Application number: 2023/91280	
What is the application for?:	Quarrying operations for the extraction of clay, shale and incidental coal and s
Address of the site or building:	Bromley Farm Quarry, Barnsley Road, Upper Cumberworth, Huddersfield, HD8 8PD
Postcode:	S36 4HG

Type of comment: An objection	
Do you wish your comments to be published on the website anonymously?	Yes
I have a number of comments. 1. You sent, what amounts to a revised application, which landed on my computer at 14.27 on the 4th of February 2025. Your date for the end of consultation is 18th February 2025. The normal consultation period for small applications is 21 days and for large schemes, which impact on the community at large, much more time is normally allowed. So could you give any good reason for the cut off date being 14 days? The original application was not advertised properly as only two notices were posted in very obscure positions when the main area of impact was the whole of the village of Upper Cumberworth. 2. Under the heading of flood risk. How will surface water be disposed of? They answer by soakaway. This wont work on a clay site, which is the sole purpose for Wavin's presence. Clay is imp

HGV ROUTING PLAN

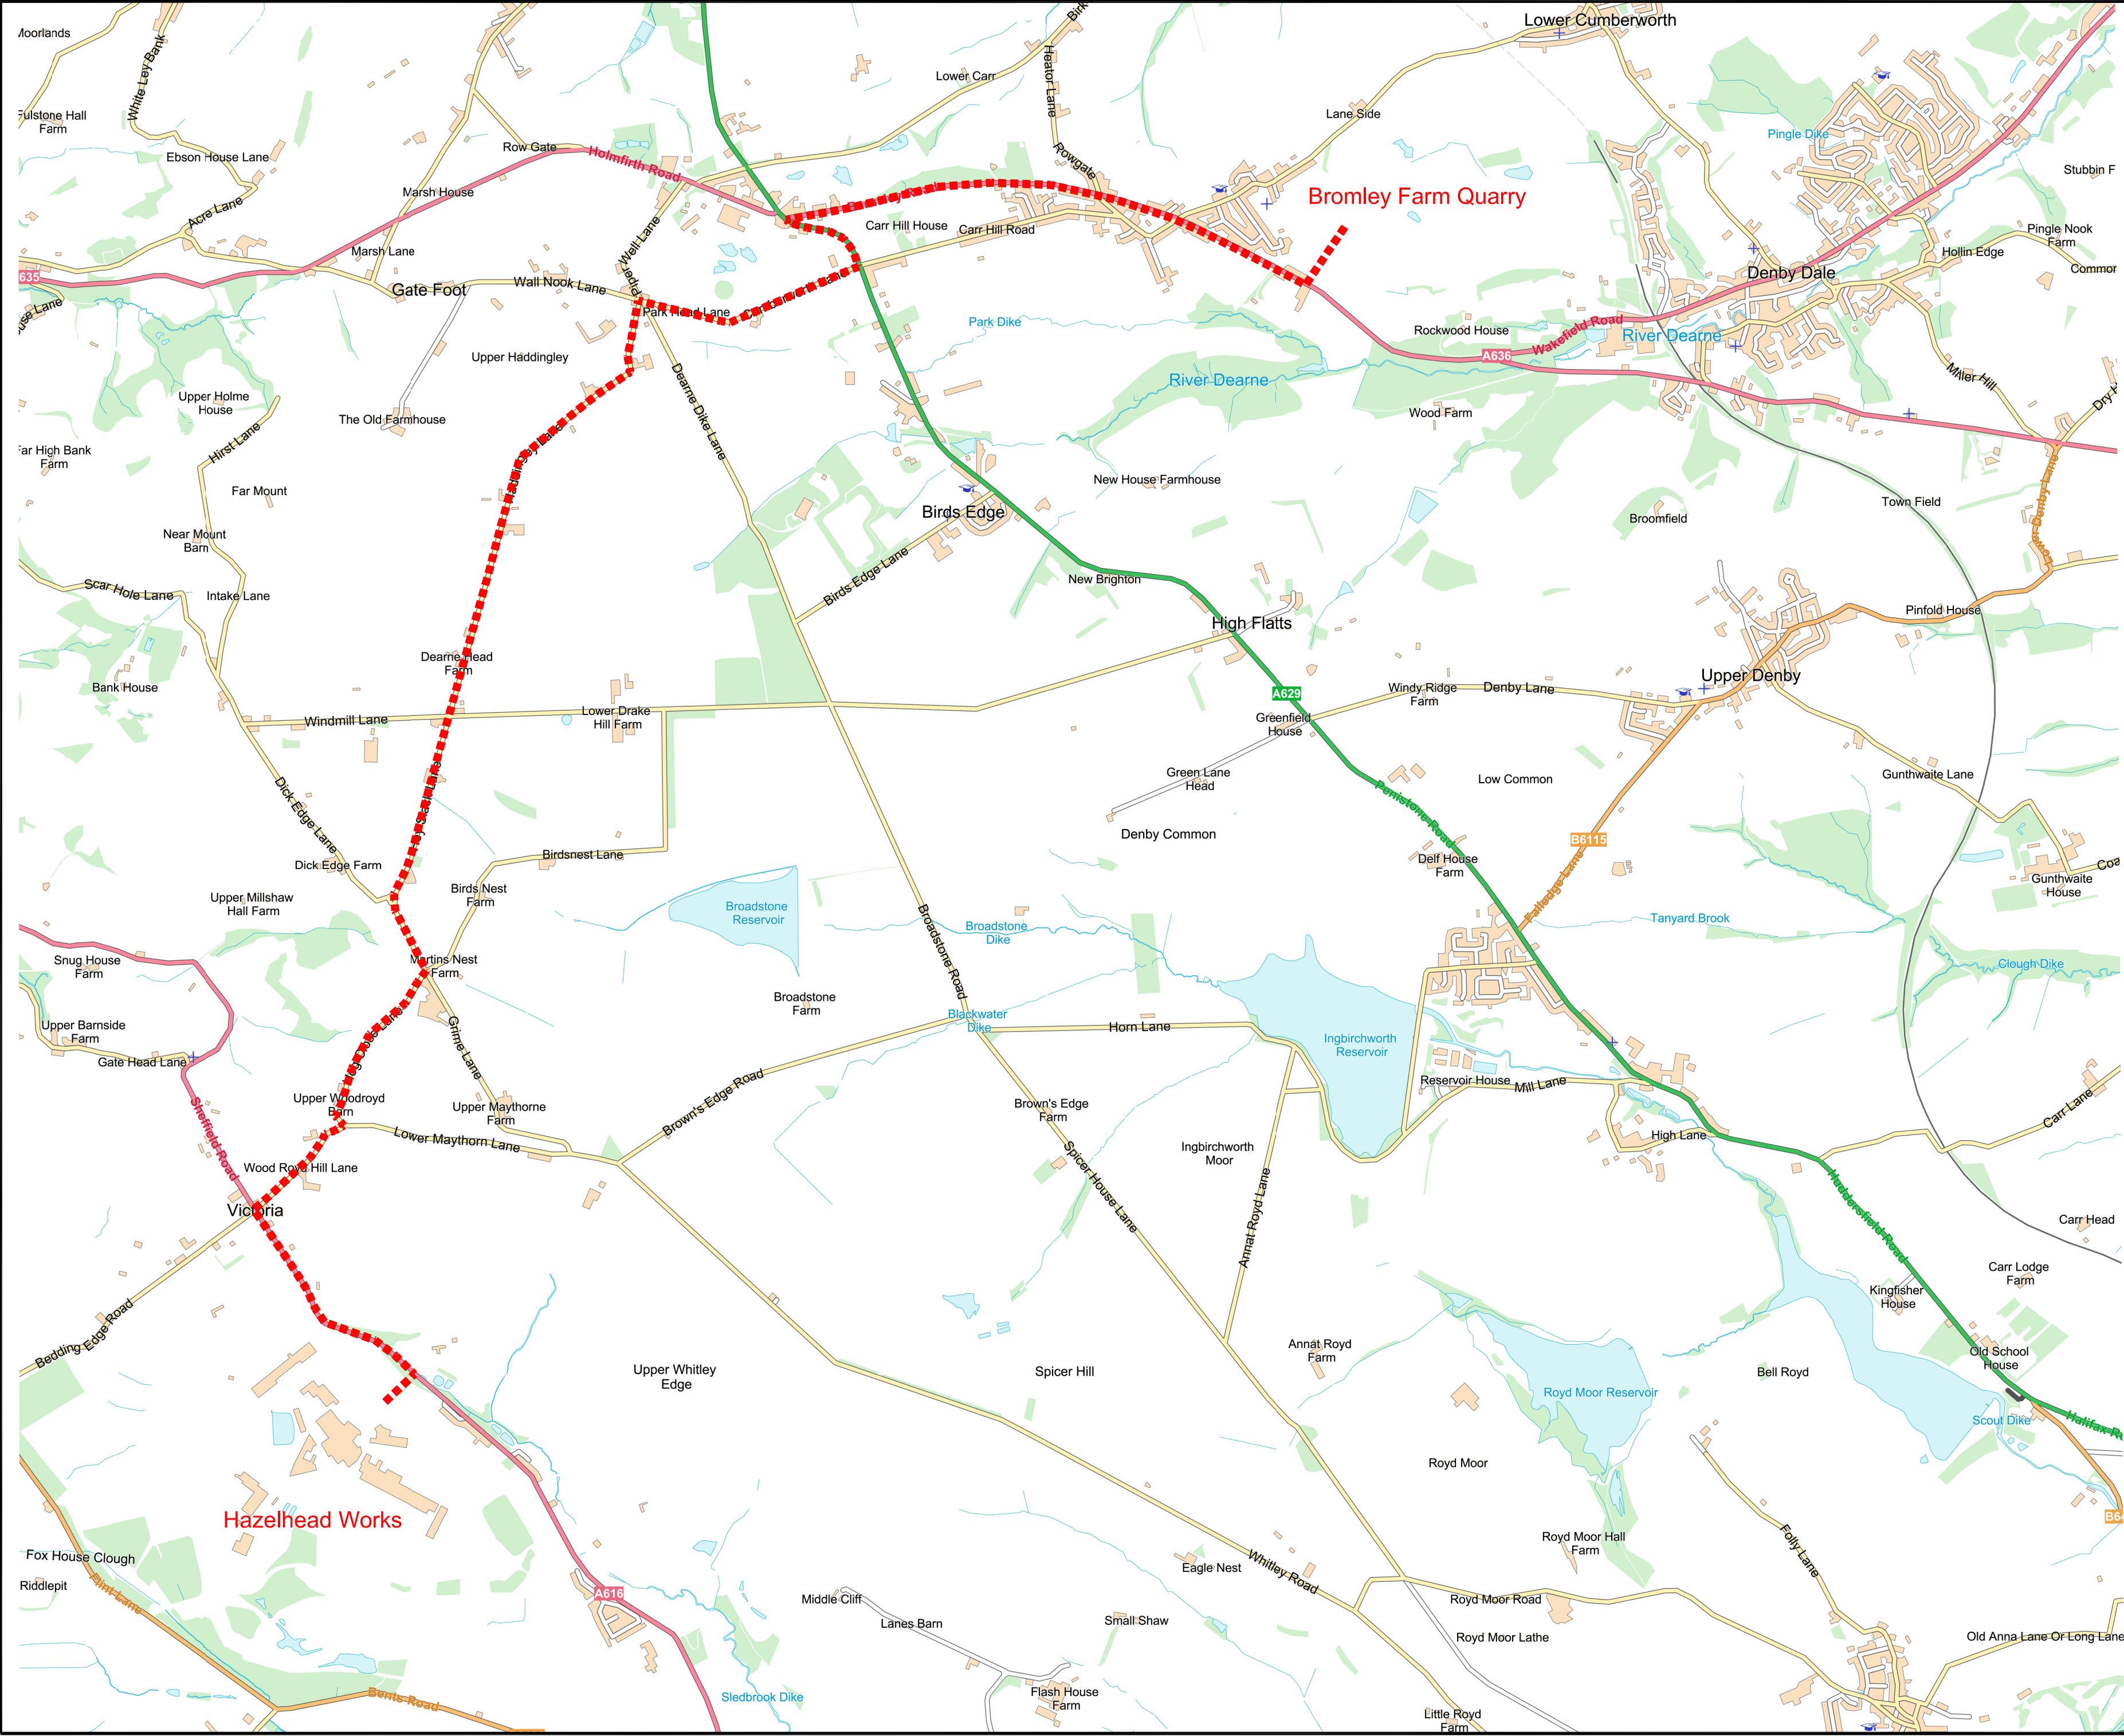
5. The plan [id 10785368] shows articulated trucks using the route. I can't imagine Wavin wanting to use this type of vehicle but the vehicle type and weight limit should be stated in the application if it is to be enforced.

6. With regard to the proposed routes, fully loaded via Barnsley Road to the Sovereign to New Mill and up to Crow Edge and empty cross country back to the Sovereign and then two way traffic down Barnsley Road to the quarry. Who is going to monitor that these routes are adhered to, and more importantly, what will the penalties be for Wavin if these routes are ignored; as I am sure they very quickly will be.
